From: Sheila Dorsett [REDACTED]
Sent: 14 December 2017 10:24
To: Richard Temple; MELVYN BLACKHOLLER
Subject: BR/280/17/PL 8 Mead Court

Front Elevation

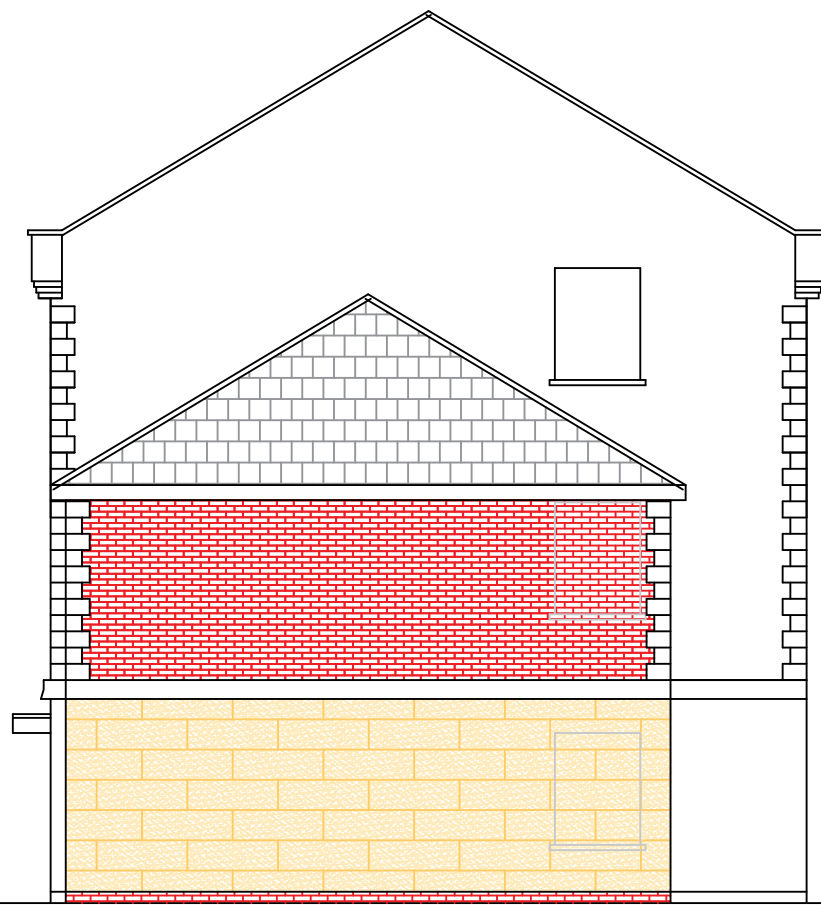
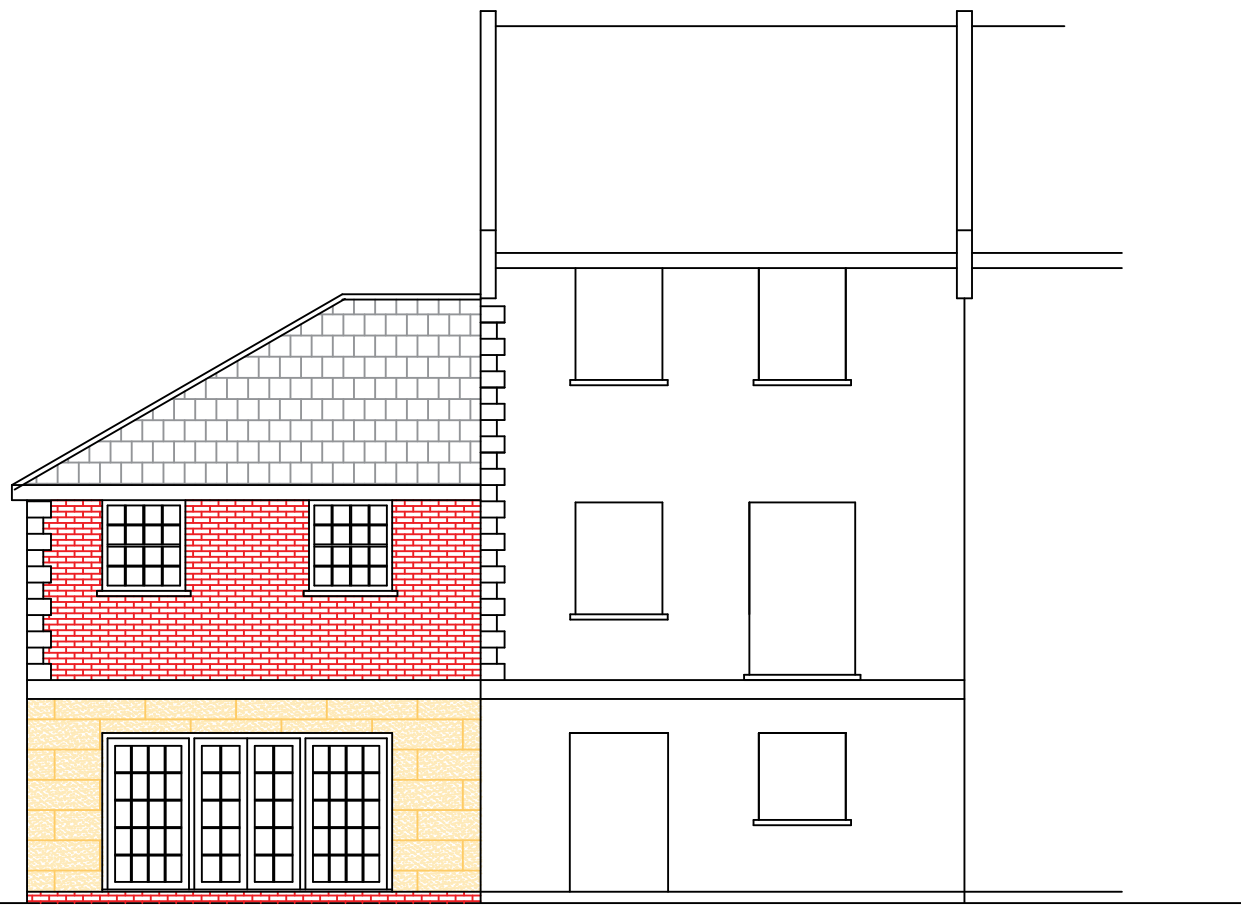
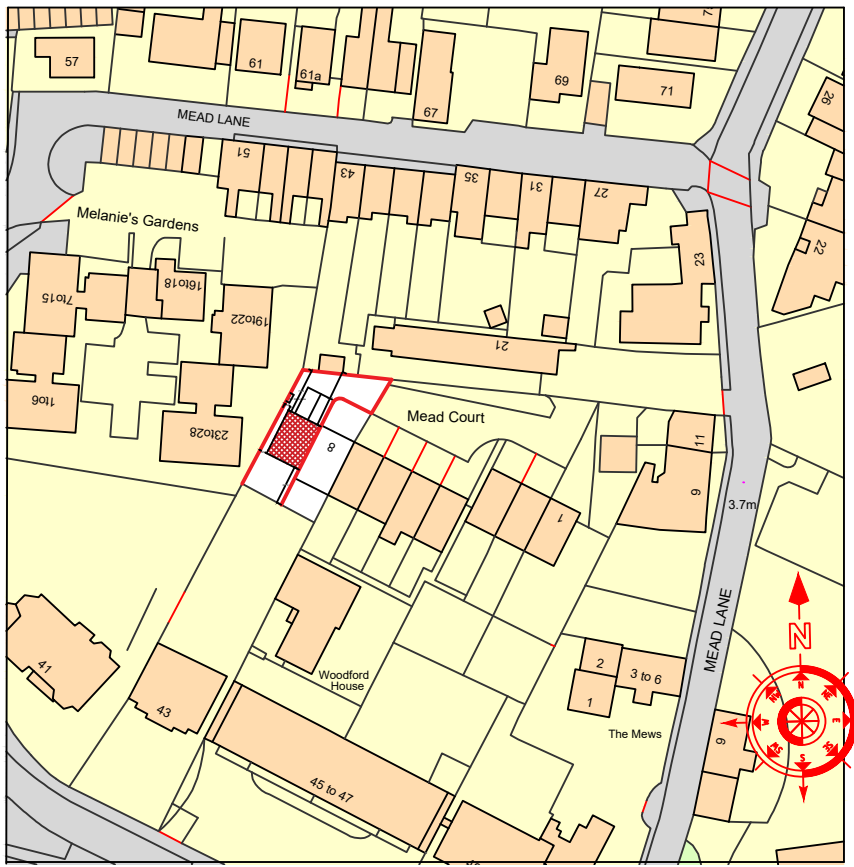
Looking at the drawings the proposed house does not appear to fit in with the rest of Mead Court; or even complement the existing buildings. Mead Court was designed, I imagine, to harmonise with Spencer Terrace.

Block plan 1 : 500

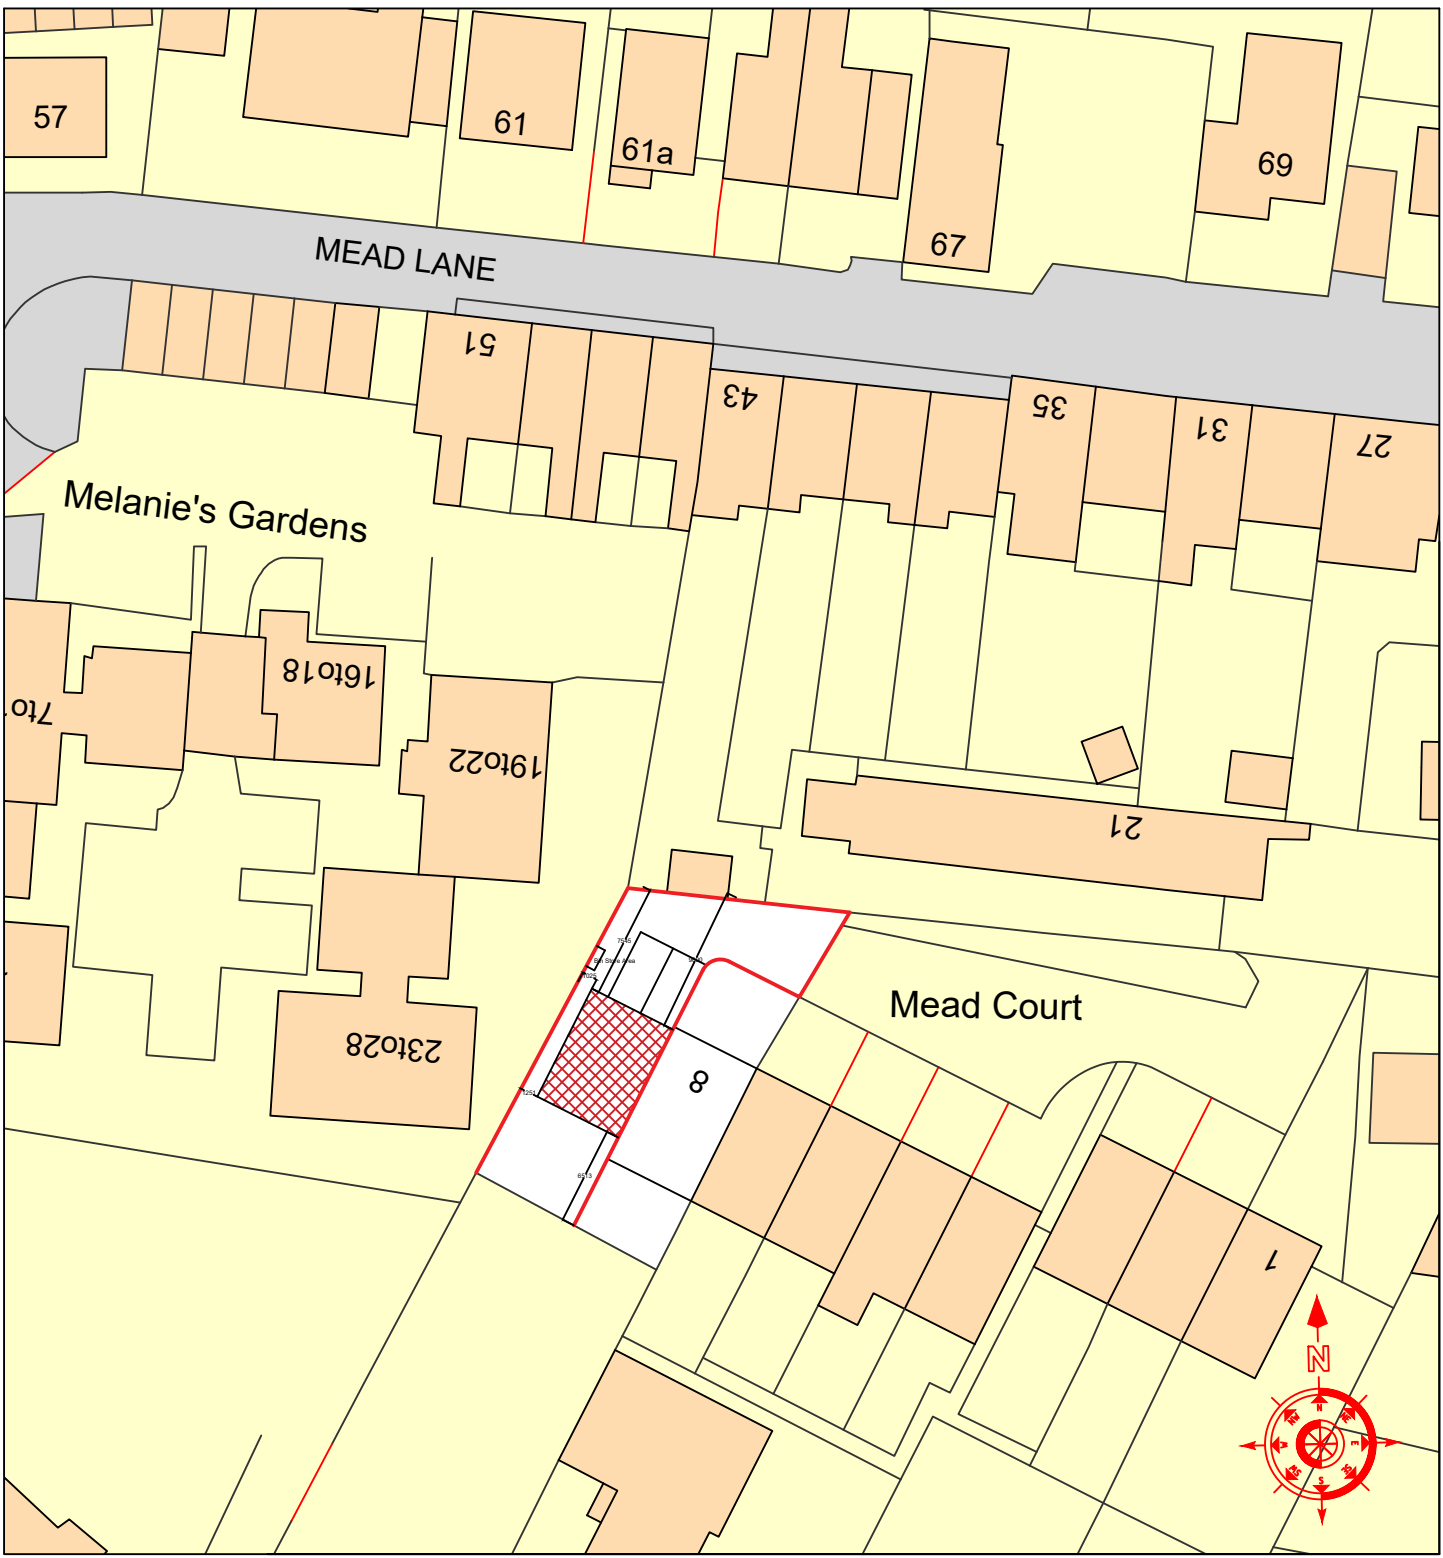
There does not seem to be sufficient space to build the new house, provide parking and an outside area, leaving number 8, a large family house, with adequate provision of the same.

The land in front of numbers 1 to 7 is owned by those properties. Without permission from the owner, it would not be available to residents, visitors or construction workers to any other property.

The new house would be very close to the adjacent flats. I believe these flats are rented and trust that the owners opinions have been sought.
